Application Ref: H16-1089-25

Proposal: **Proposed conversion of existing barns to office use and the development of a padel club on adjacent land**

Location: **Bridge Farm, Holbeach Road, Spalding, PE12 6JP**

Date: 03rd December 2025

PROPOSED SITE PLAN INC. FENCING ELEVATIONS

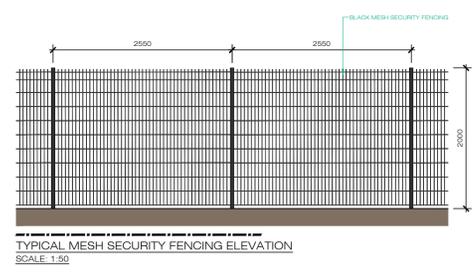
I understand that this is a full planning application for the proposed conversion of existing barns to office use and the development of a padel club on adjacent land. In terms of parking provision, 25no. spaces have been allocated to the office building and 14no. spaces to the padel court leisure facility, including cycle storage facilities. The operating hours for the professional services will be Monday-Friday (8am-6pm) and the leisure facility will be Monday-Friday (6am-9pm) and Saturday-Sunday (6am-6pm). Additionally, there will be 20 full time and 4 part-time staff members for the leisure facility, as we understand.

That said, the Highway Authority are of concern with the proposed parking numbers not being sufficient for the proposed use of the leisure facility, this being only 14no. and therefore, we would ask the applicant for further justification on how many appointments will

there be per day, how long the appointments are, spacing of visiting times and, if pre-booking arrangements of appointments is requested, including the number of staff members working at one time or on one shift. Essentially, we need to know how many vehicles will be on site at any one time, to ensure sufficient parking provision has been accounted for and to ensure vehicular movements of those arriving for an appointment, would not meet those departing from an appointment that has ended, if visiting times were equally spaced and for staff members.
